Our ref: NA/2020/115279/01-L01
Your ref: TR010059
Date: 22 December 2020

**A1 IN NORTHUMBERLAND: MORPETH TO ELLINGHAM:
REPRESENTATIONS IN RESPONSE TO PRELIMINARY MEETING 15
DECEMBER 2020. PROCEDURAL DEADLINE B. MORPETH TO ELLINGHAM**

Temporary Works at the River Coquet

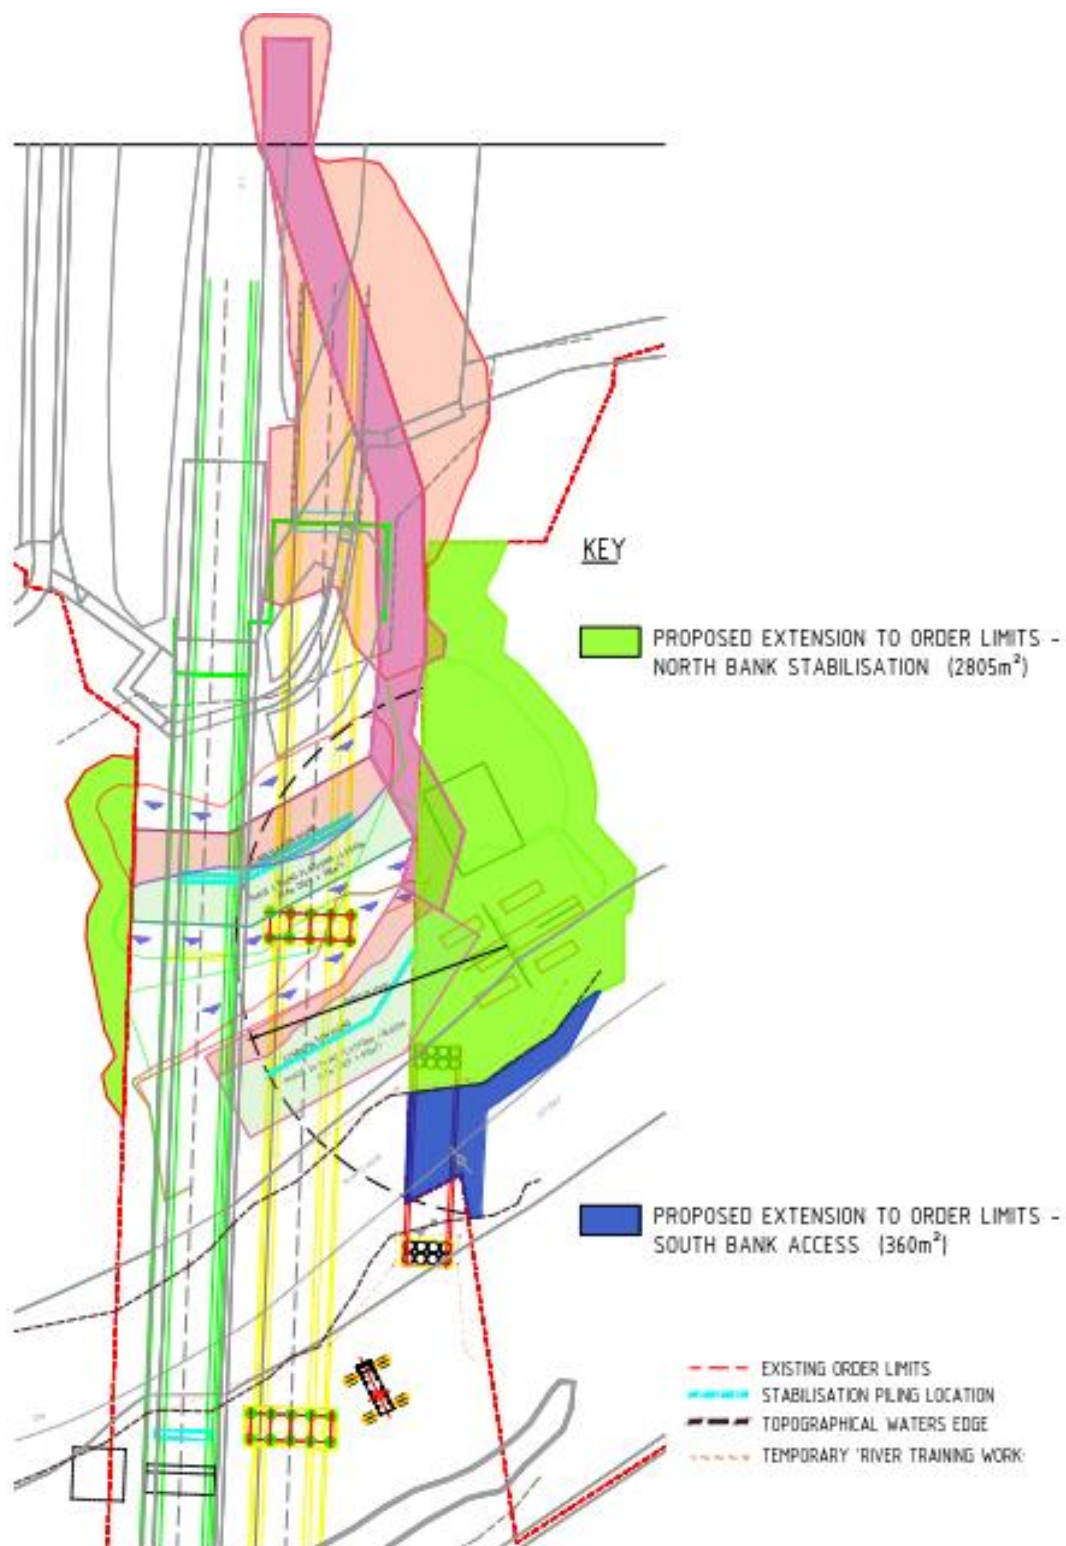
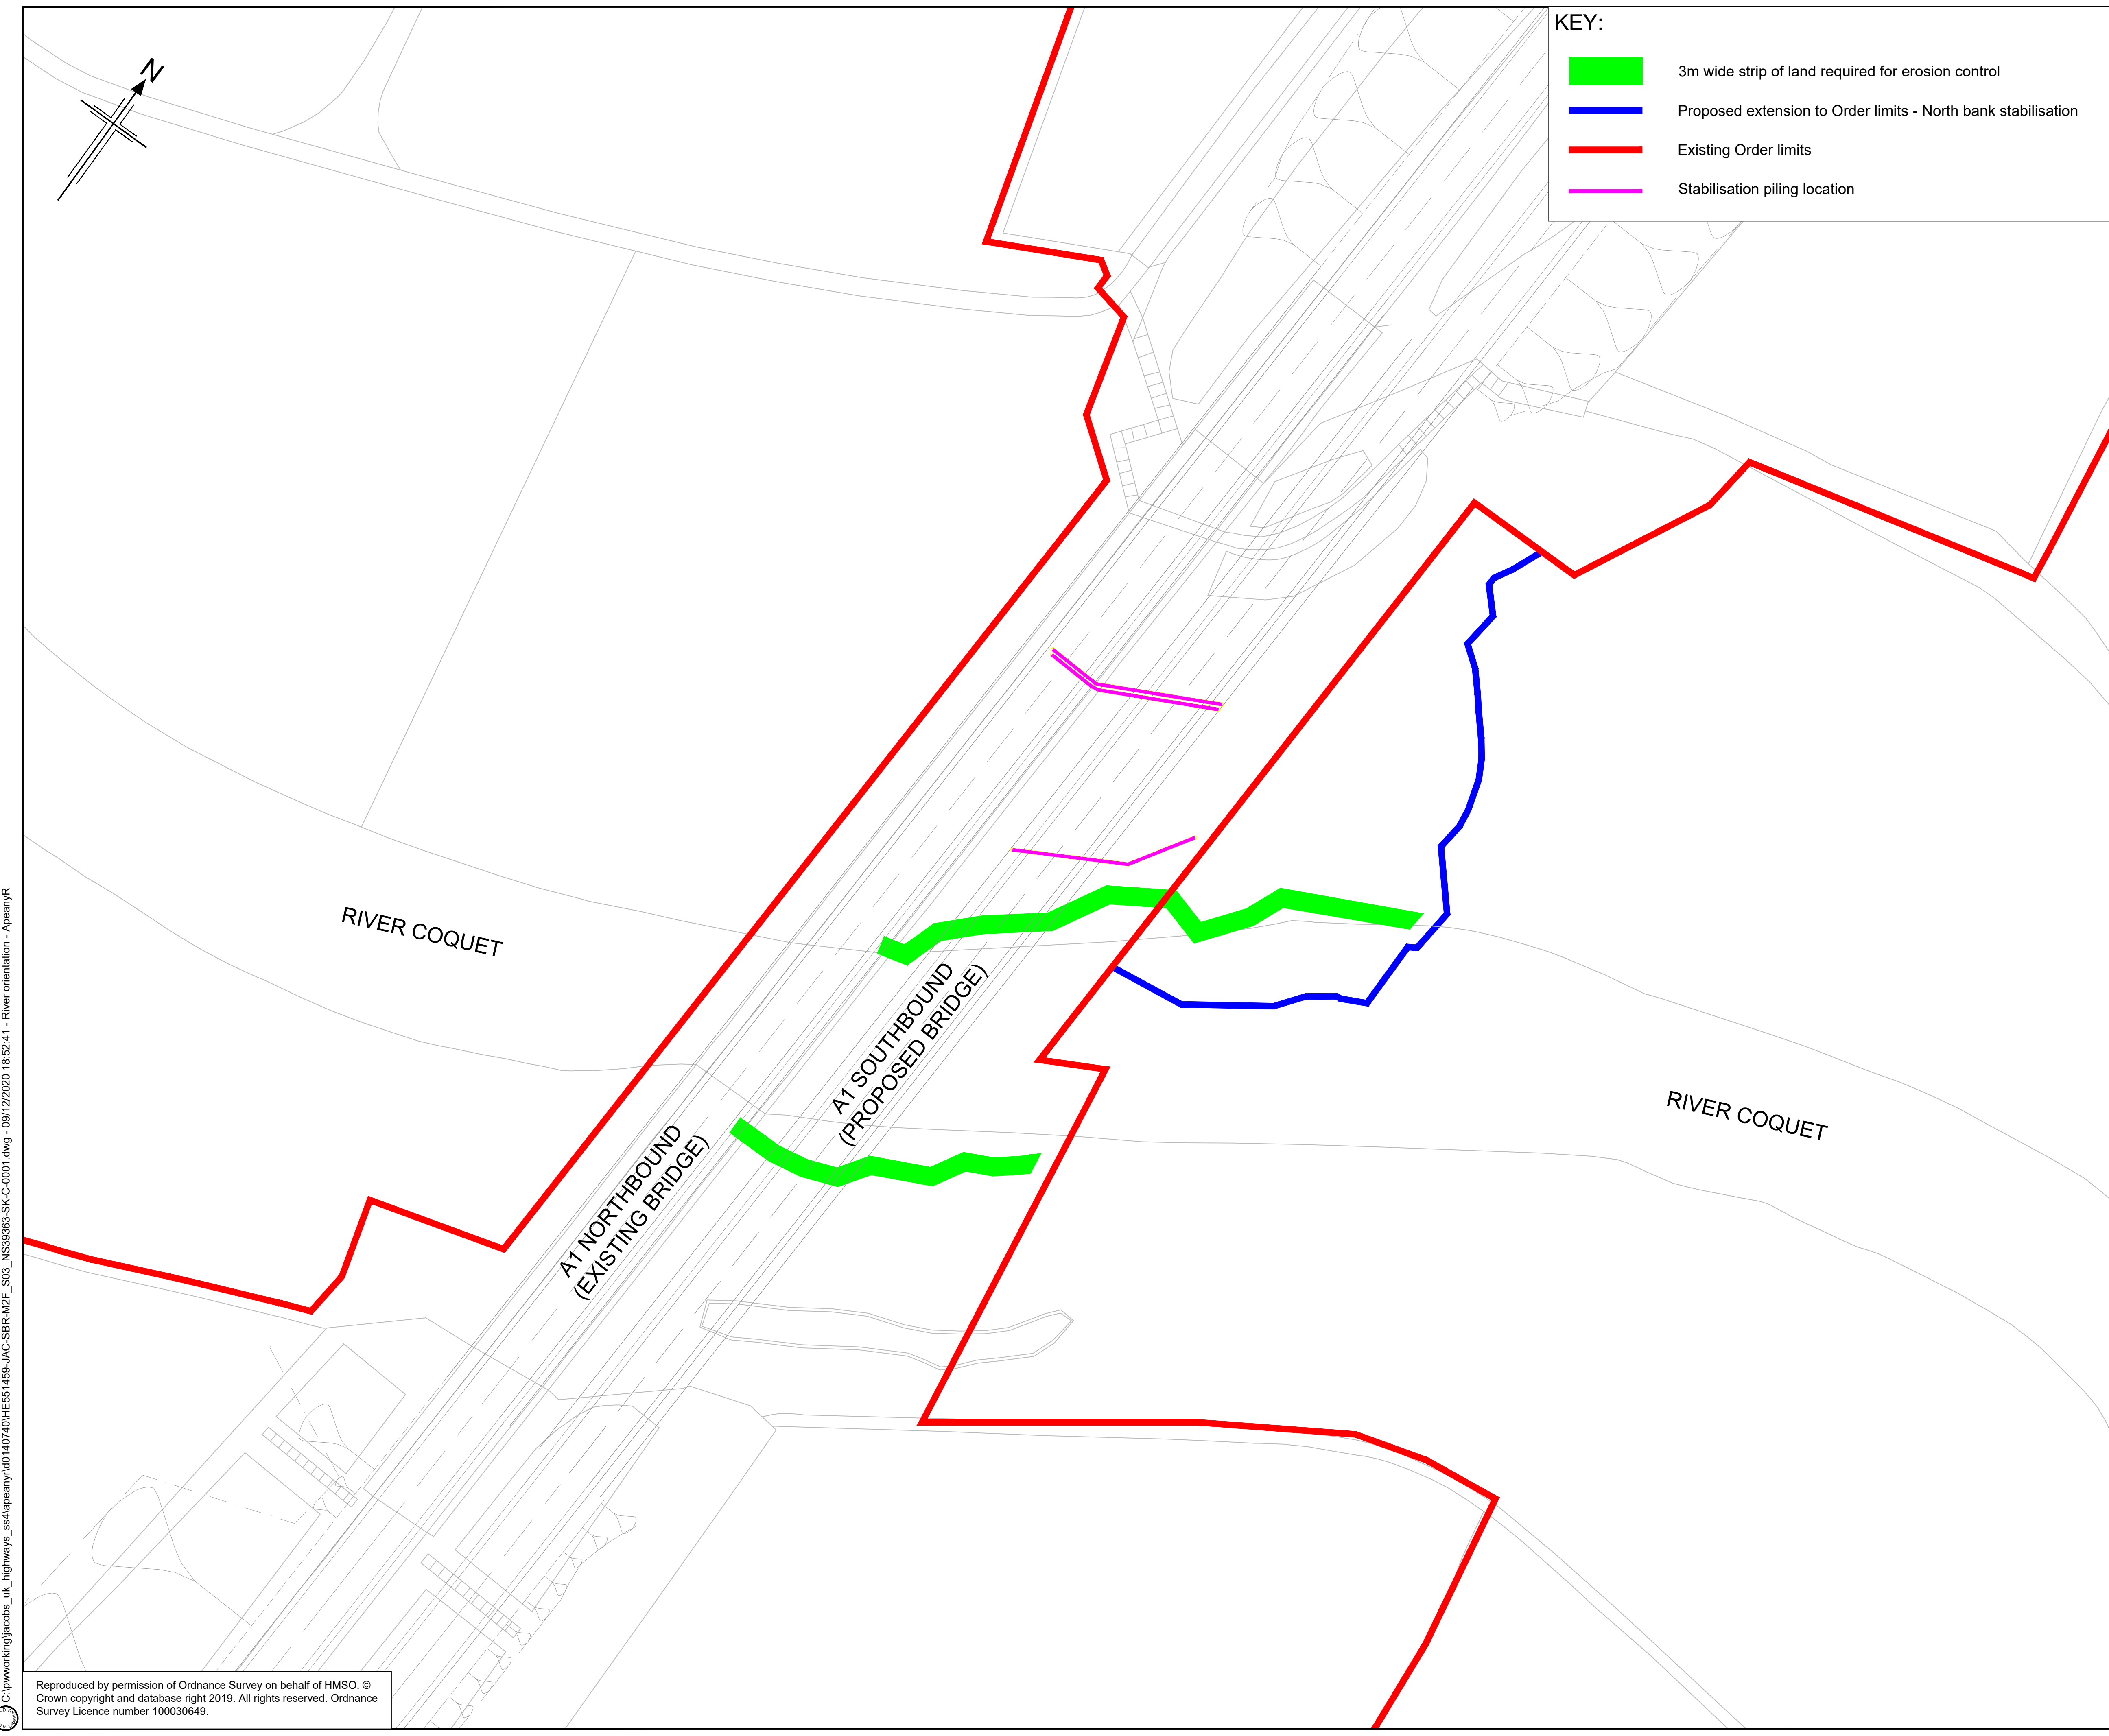
Proposed change 1: alteration of the location of the southern pier of the bridge: moving it 2m closer to the river's edge.

This will have flood risk, ecology and geomorphology and Water Framework Directive (WFD) impacts, which will need to be assessed as part of the DCO. This may include the need for additional surveys to be undertaken.

Proposed change 2: installation of temporary bridge and river training works for approximately 15months)

This is a significant change and consequently further flood risk, ecology, WFD and geomorphology information will need to be submitted as part of the DCO, including additional design information for the temporary bridge and river training measures. Additional surveys may need to be undertaken.

The design of the temporary bridge will need to be supported with hydraulic modelling, in order to ensure that there is no increase in flood risk elsewhere. The hydraulic model will take between 6-8 weeks to review. The Flood Risk Assessment will also need to be updated to reflect the proposed changes to the permanent bridge structure (bridge pier locations) and the introduction of a temporary bridge and increased in-river works.

Any river training should not damage existing geomorphological features of value at the site or downstream. Any changes will need to be monitored and if impacts are experienced, they must be compensated for.

Proposed change 3: the installation of bank protection (potentially rock armour) on the north bank of the river to address the risk of fluvial erosion and instability of the sloping land north of the riverbank.

This will have flood risk, ecology and geomorphology impacts, which will need to be assessed as part of the DCO. The proposed permanent use of bank protection may destroy/severely damage the bank habitat and geomorphological process along the River Coquet.

Rock armour is not favourable due to its visual and geomorphological impact and the limitations it can pose on ecology. Furthermore it is also unlikely to have a lifespan to match that of the bridge. The River Coquet is largely unmodified and any increase in the heavily modification (as classed under WFD) will need to be compensated for, e.g. the removal of rock armour and renaturalisation in other areas.

Proposed change 4: the addition of rock armour on the southern bank of the river for erosion control purposes where it is not clear where any significant erosion exists.

This will have flood risk, ecology, WFD and geomorphology impacts, which will need to be reassessed as part of the DCO. Additional geomorphological surveys may need to be undertaken and additional mitigation measures provided. Local factors need to be considered when assessing the need for rock armour, such as bedrock present at the pier location or whether green methods can be utilised.

Proposed change 5: Larger area for construction required on the north bank, increasing pollution risk to River Coquet

A larger area of exposed soils on the northern bank will result in a greater risk of the creation and accumulation of site water with a high sediment load. Due to the nature of the works, there will be limited area to treat the water through standard methods such as settlement lagoons. A bespoke plan for treating the anticipated volumes and chemistry of the water should be developed, this must take into

account any permits that may be required taking into account the designated receiving waters if using chemical dosing.

Proposed change 6: installation of two rows of spaced piles to the north side of the proposed pier location and a third row to the south side

This could potentially create or a break groundwater pathways along the River Coquet. Therefore, the risk of the groundwater will need to be reassessed as part of the DCO and mitigation may need to be provided.
